**Our Ref: BR/129/11/
Your Ref:**

Replacement first floor bay to front elevation and installation of additional second floor bay to match.

Langford House 7 The Steyne Bognor Regis

I regret that I am unable to accept your documents as a formal application until the following matters have been resolved :-

ROOF PLANS 1 : 100

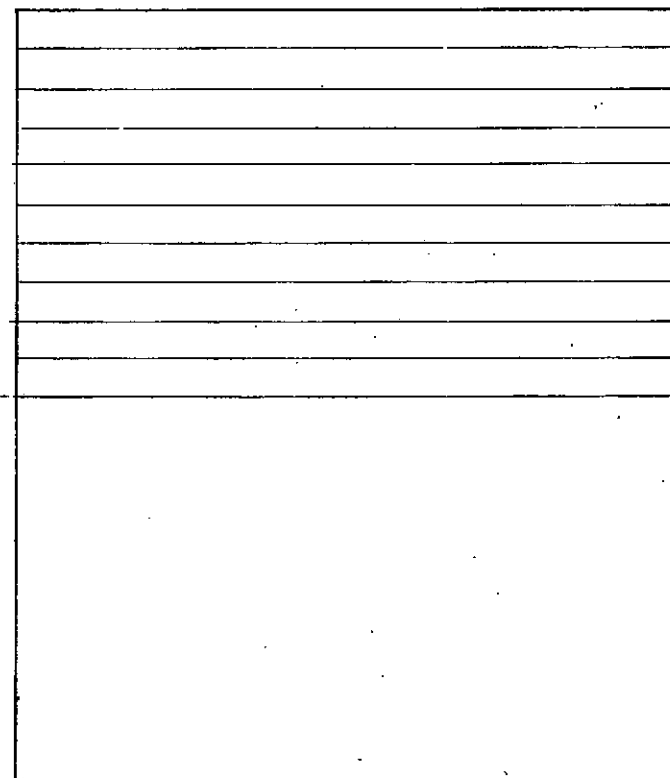
- ☒ Please submit 1 electronic or 3 paper copies of existing and proposed roof plan in accordance with guidance notes available on our website detailed below (click on National List).

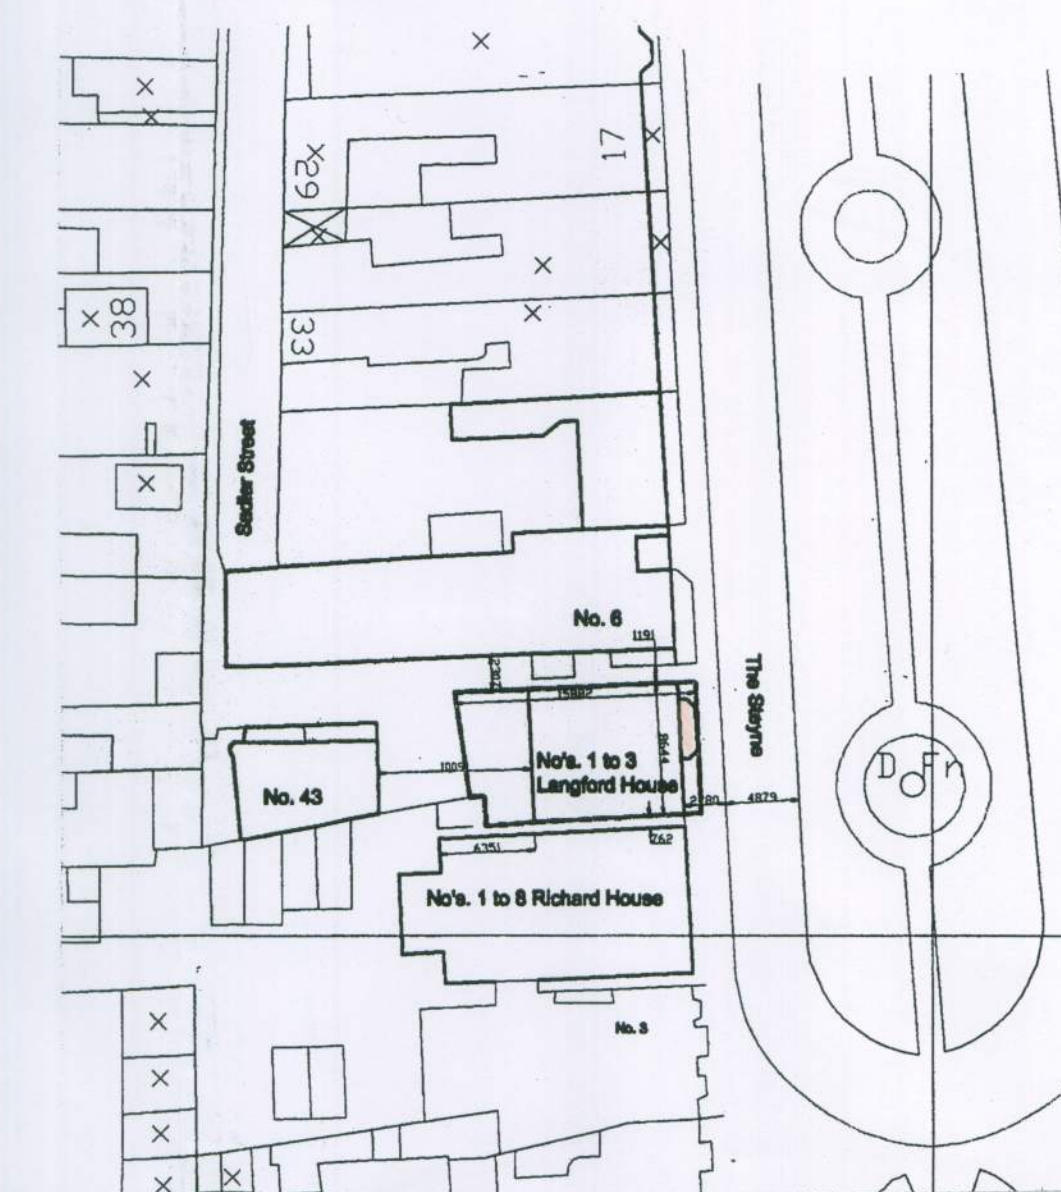
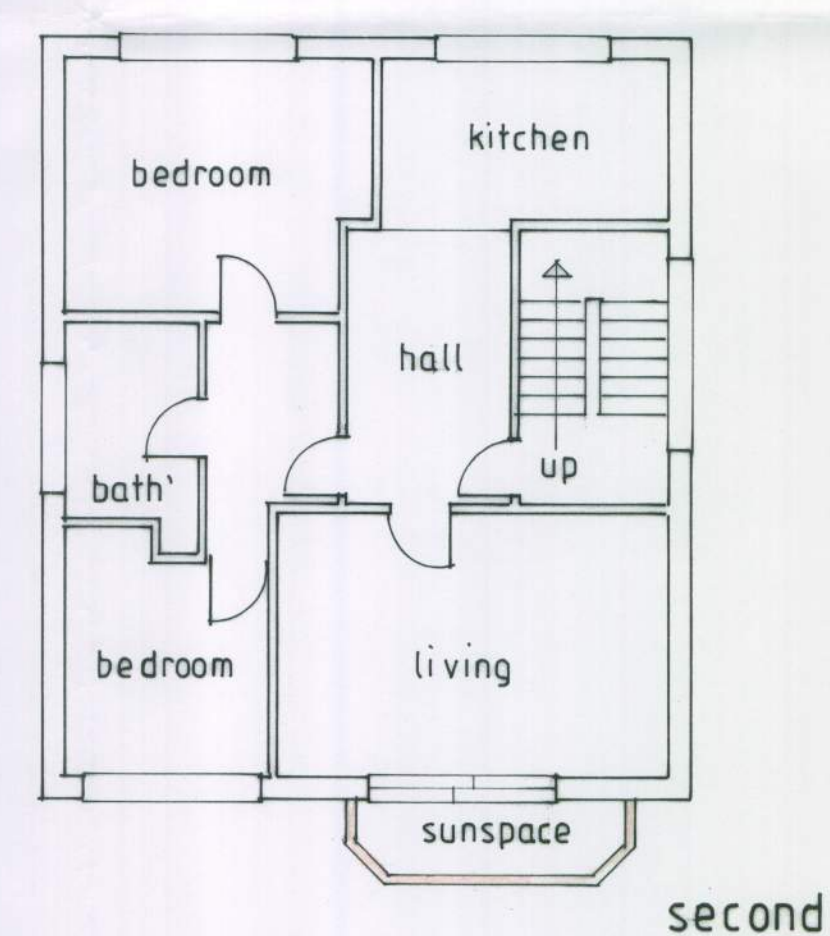
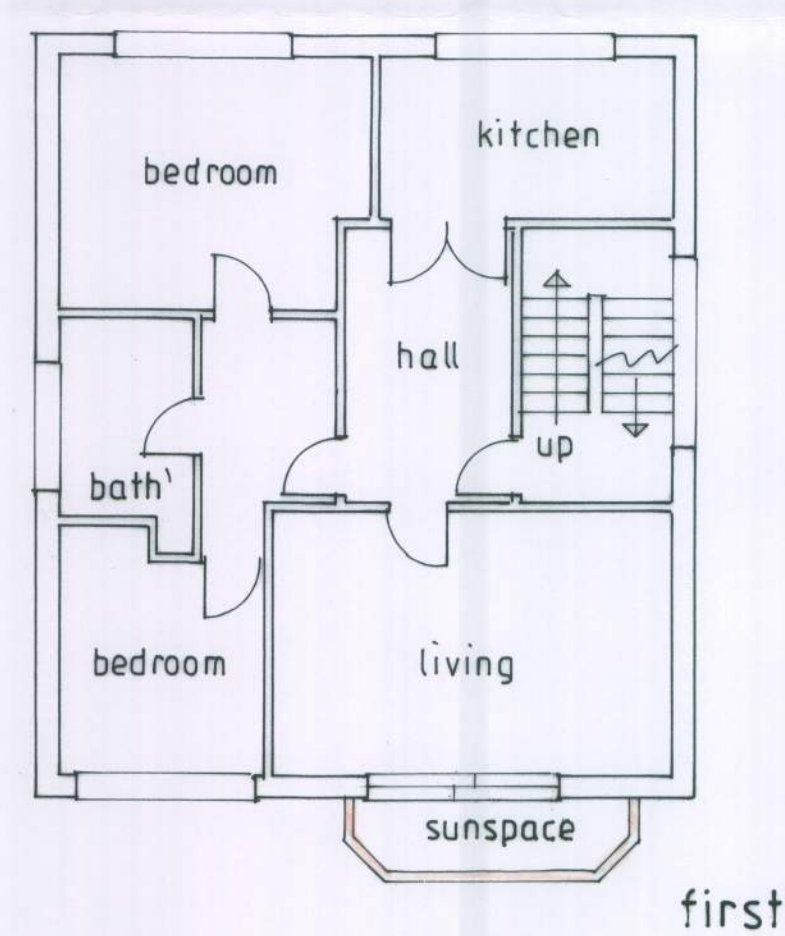
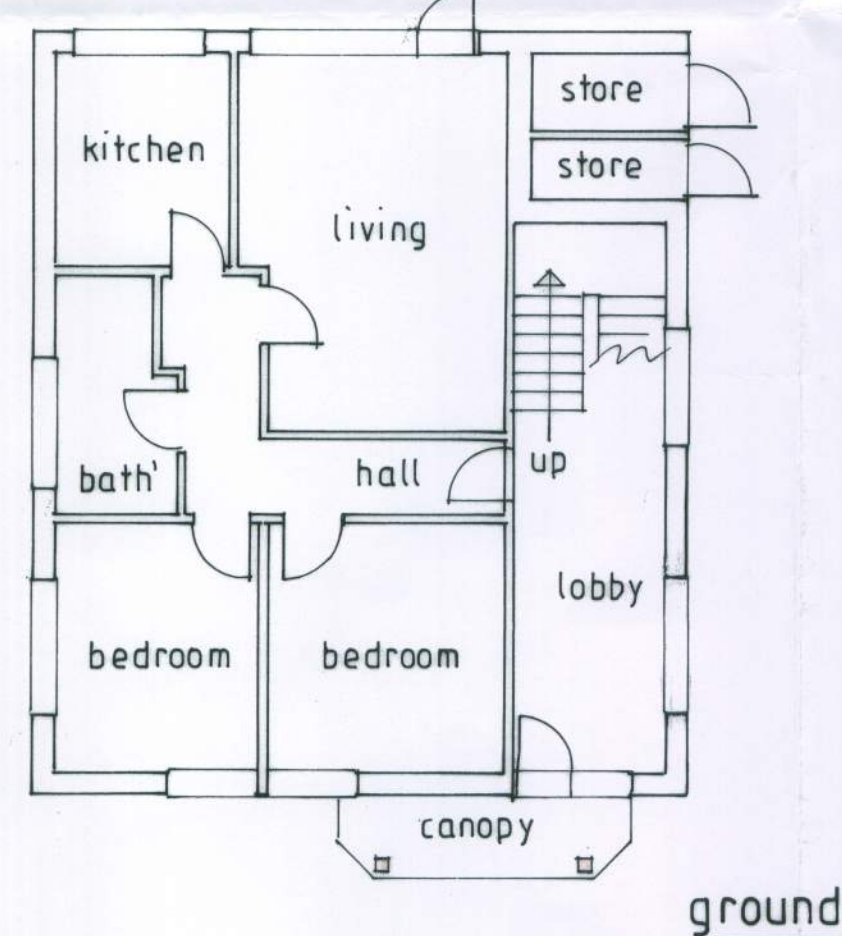
- ☒ Please provide 1 electronic or 3 paper copies of amended existing floor plans to show all windows and doors to match existing elevations at a scale of 1:50 in accordance with the guidance notes available on our website detailed below (click on National List).

- ☒ Please provide 1 electronic or 3 paper copies of amended proposed floor plan (Side N) to show window in lobby at a scale of 1:50 in accordance with the guidance notes available on our website detailed below (click on National List).
